From
The Member Secretary,
Madras Metropolitan
Development Authority,
Thalamuthu-Natarajan Building,
No.8, Gandhi Irwin Road,
MADRAS: 600 008

Lr.No. A1/348/90

Sub: MMDA - Planning permission - Construction
of Residential/
building in Plot No. D at S.No.100 of
Okkiam Thuraiyakkam village - Approval of - Reg.

SITE PLAN S.C. 1"=18'0"

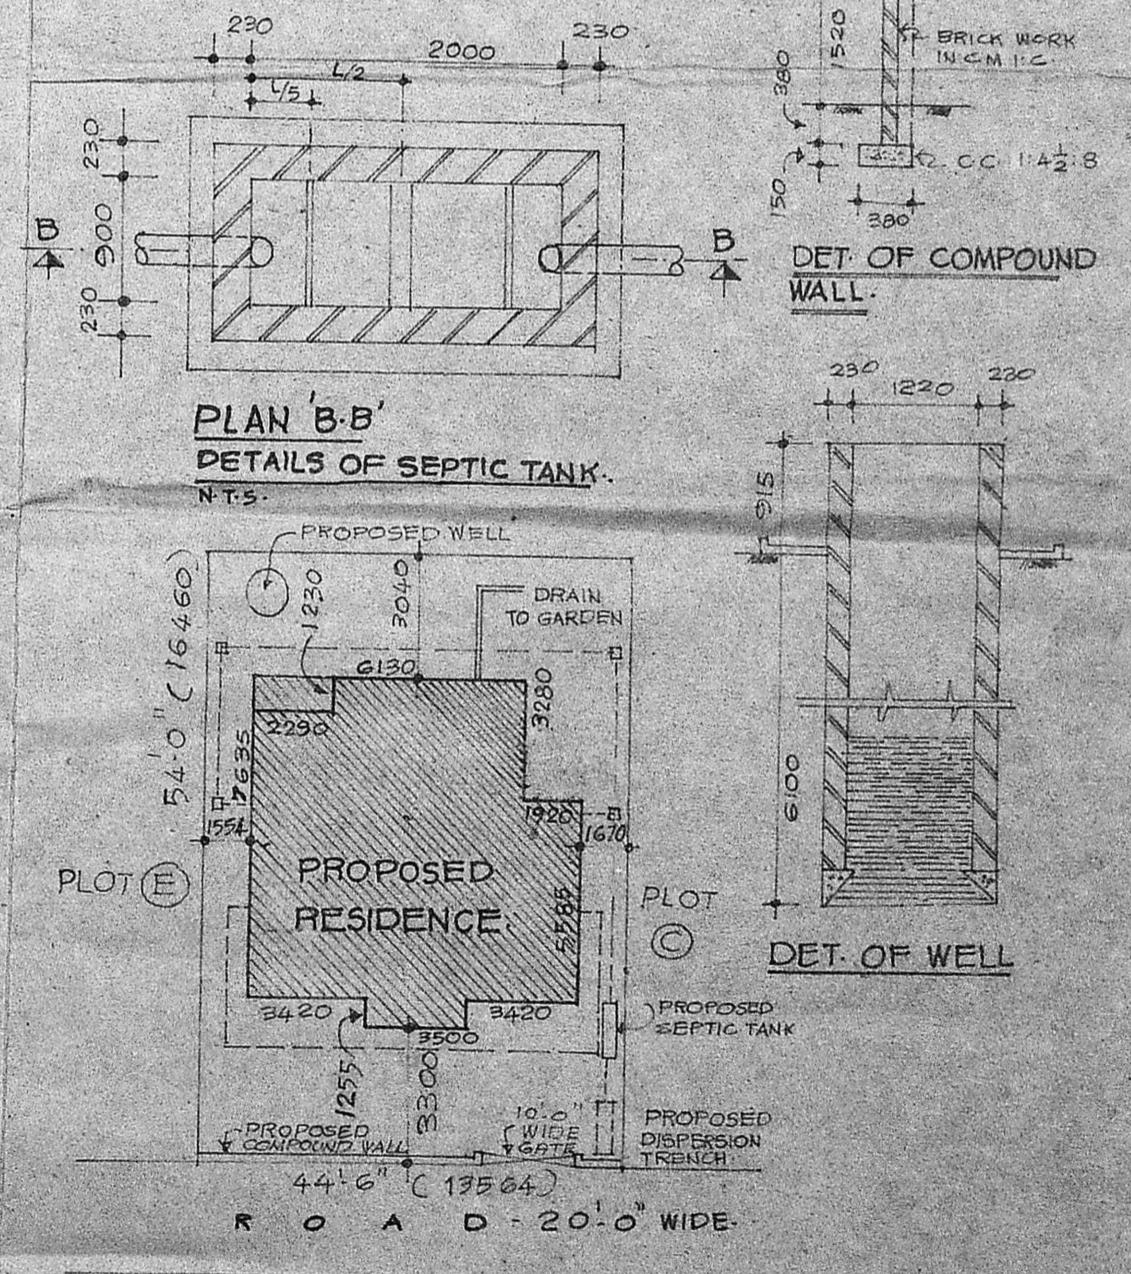
In this connection, you are requested to remit a sum of
Rs. 375/- (Rupees three hundred and seventy five only) only)
towards Development charges for land and building and Rs. 2300/-
(Rupees two thousand and three hundred only) only) towards Regularisation
charge by two separate Demand drafts of a Nationalised Bank in Madras
city drawn in favour of the Member Secretary, MMDA, Madras and submit
them at MMDA office cash counter between 10 AM to 4 PM of the receipt
of this letter within 10 days and after remitting the said amount,
you are requested to submit the duplicate receipt to Area Plans Unit
and furnish and affidavit in Five rupees stamp paper duly attested by
Notary public as per the format enclosed. Planning permission appli-
cation will be returned unapproved if the amount are not paid within
the stipulated time. Also furnish five copies of revised plans providing return of

3.00m clear.
